Subject: AL/27/20/PL - Hook Lane, Aldingbourne

Yesterday I went through the proposed floor plans to check the CIL amount and calculated the following for the new dwellings. These were done using a scale ruler and include internal walls which should actually be excluded (I haven't the patience to measure room by room) so the actual amounts should be less than my figures. However, the total new floorspace that I got is 993.03m² and this is sig less than that which you stated on the CIL form (1045m²).

Plot 1 Floor Plans 1:100@A3

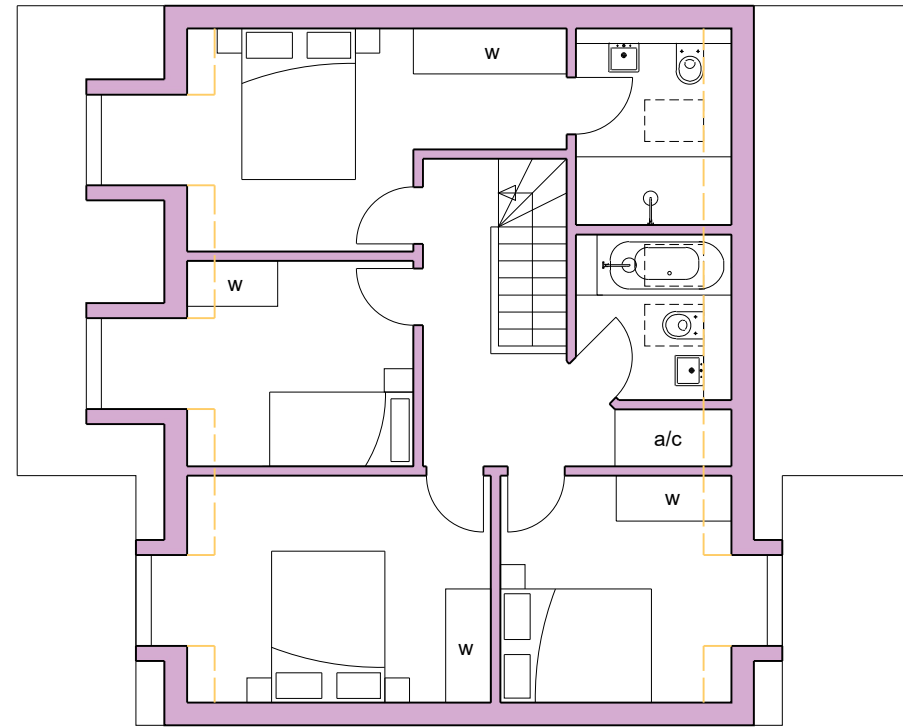
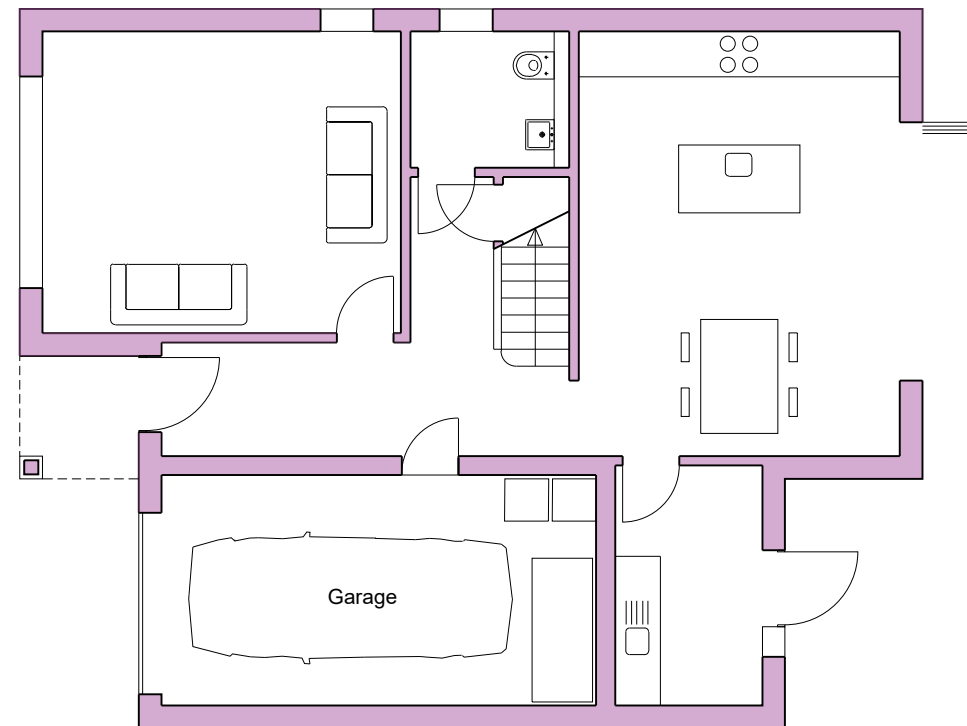
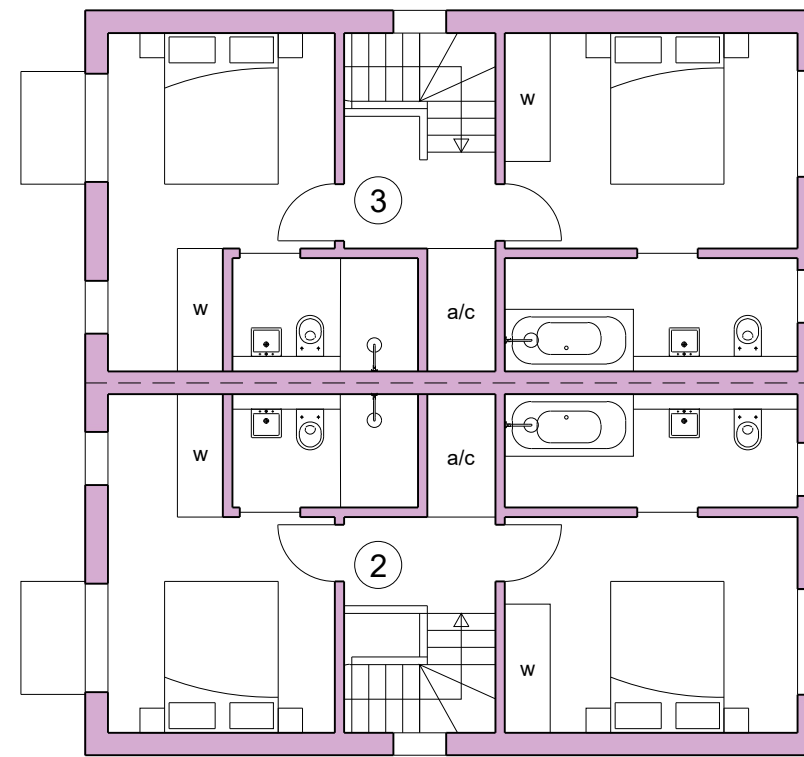
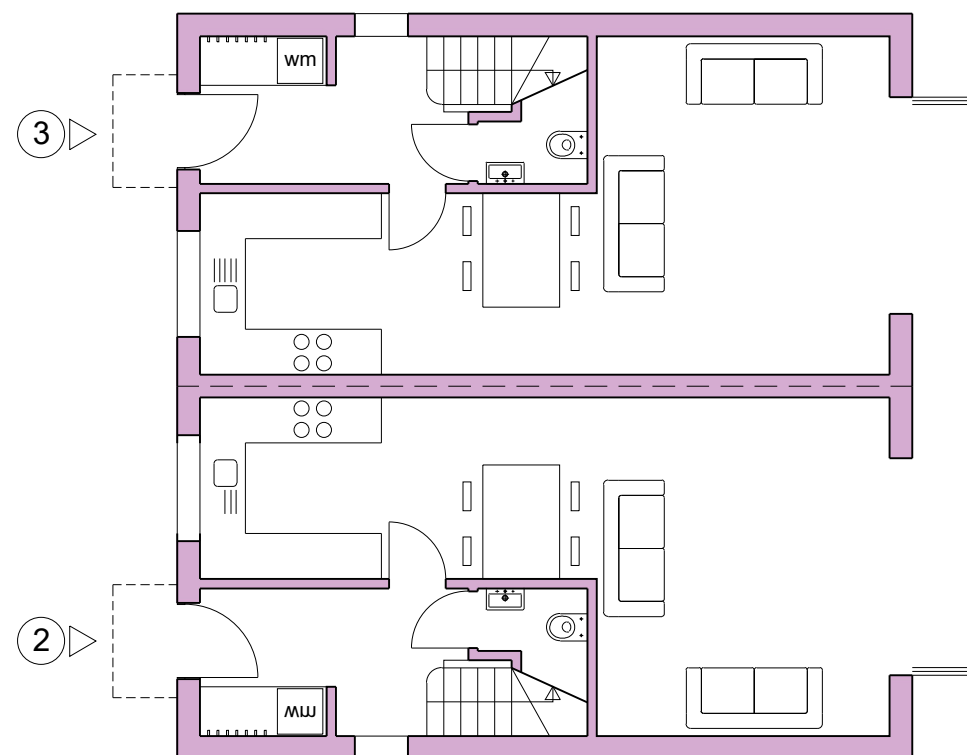
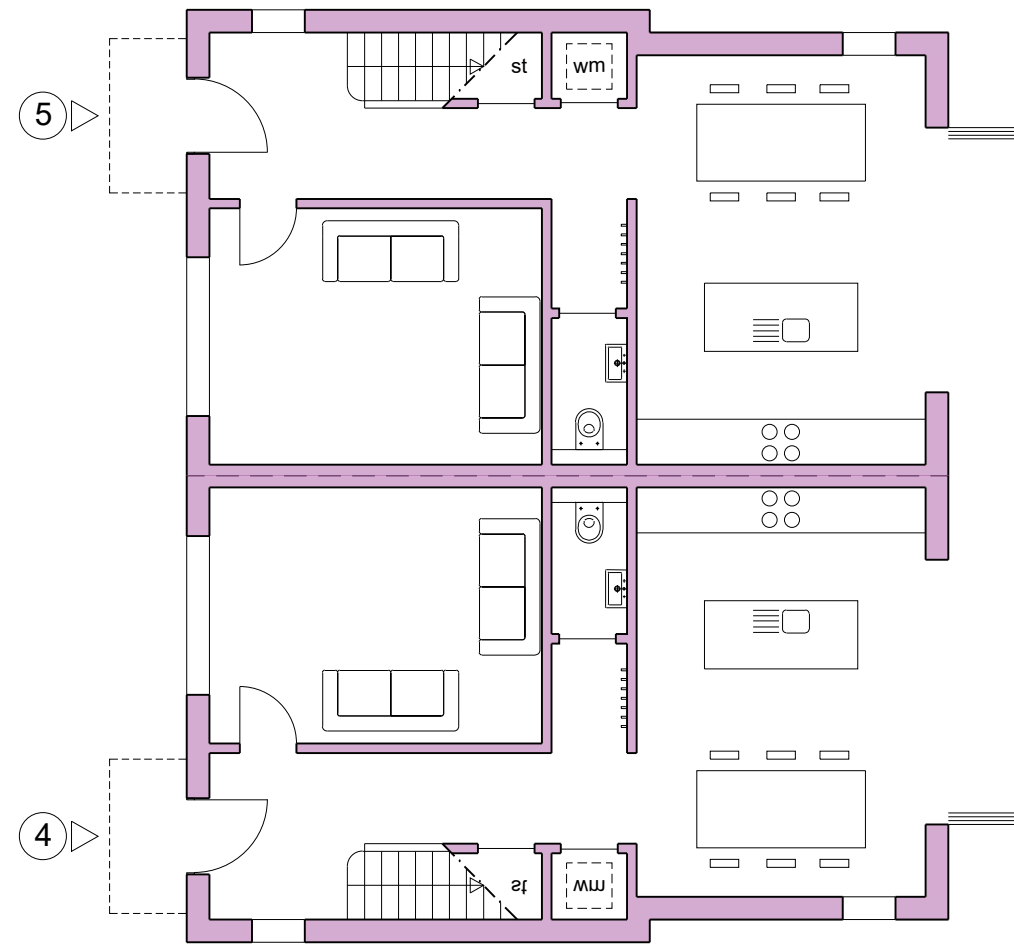
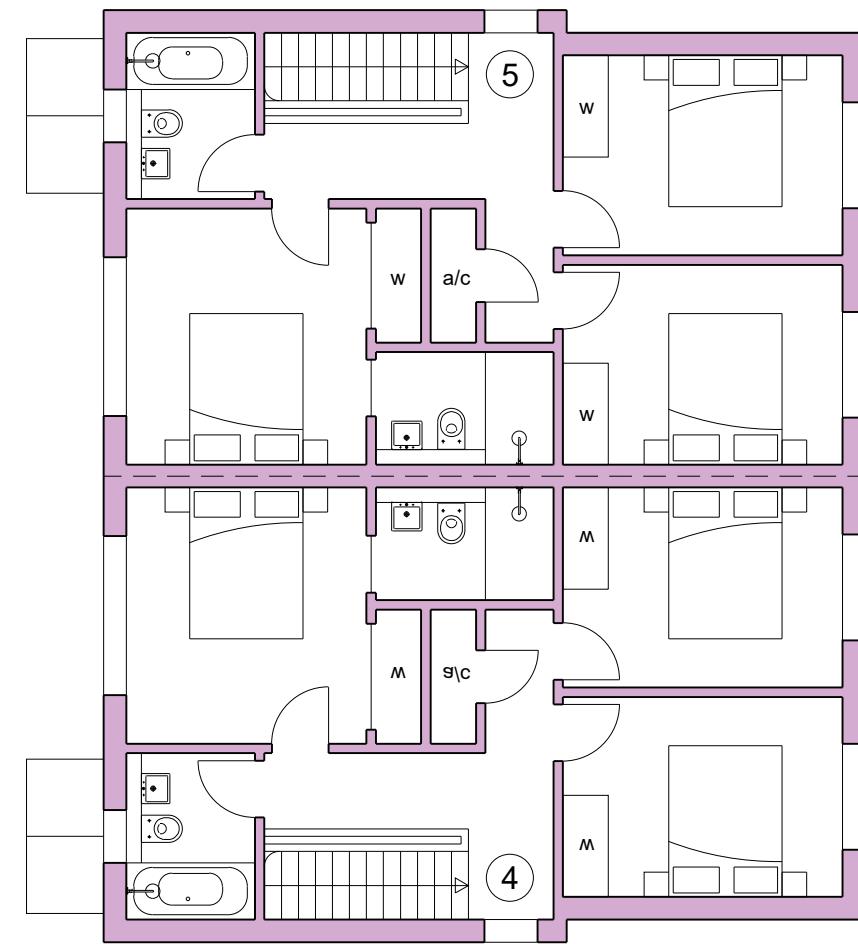
1 - 146.19m²
2 - 78.32m²
3 - 78.32m²
4 - 101.82m²
5 - 101.82m²
6 - 124.2m²
7 - 123.16m²
8 - 119.6m²
9 - 119.6m²

Could you look into this and advise whether we should go off your CIL form, my measurements or another measurement?
